Conservation officers response

P/106/25/PL

The Lion Public House Nyetimber Lane Bognor Regis PO21 3JX

Retention of timber awning to front of building.

SOUTH ELEVATION.

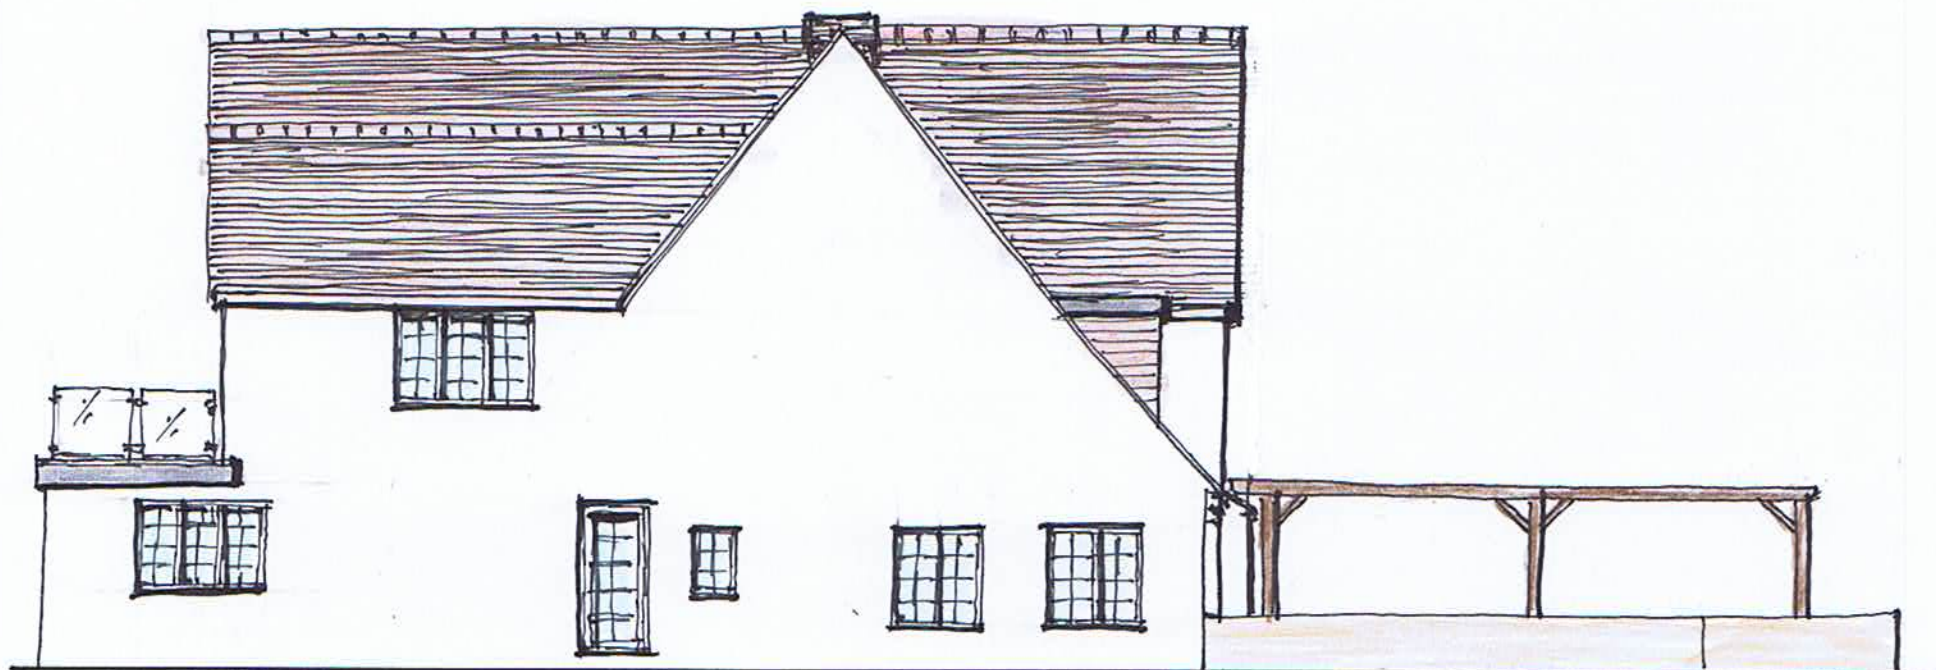
The proposal seeks retrospective consent for a timber structure described as an “awning” to the front of the building. However, it is clear that the structure is a timber pergola, with what appears to be plastic sheeting fixed to the roof to provide shelter for seating beneath.

The pergola is positioned directly in front of the principal elevation of the listed building, which is a key contributor to the building’s significance. Its placement in this location results in a greater impact than if it were situated to the side or rear, where it would be less visually and historically intrusive.

The structure appears visually intrusive and out of keeping with the historic character of the building. Its design, materials, and scale do not relate well to the architecture of the listed building, and it obscures views of the main elevation, preventing it from being properly appreciated.

As a result, the pergola is considered a permanent and harmful addition that detracts from the special interest of the listed building. It is not acceptable in this sensitive and prominent location.
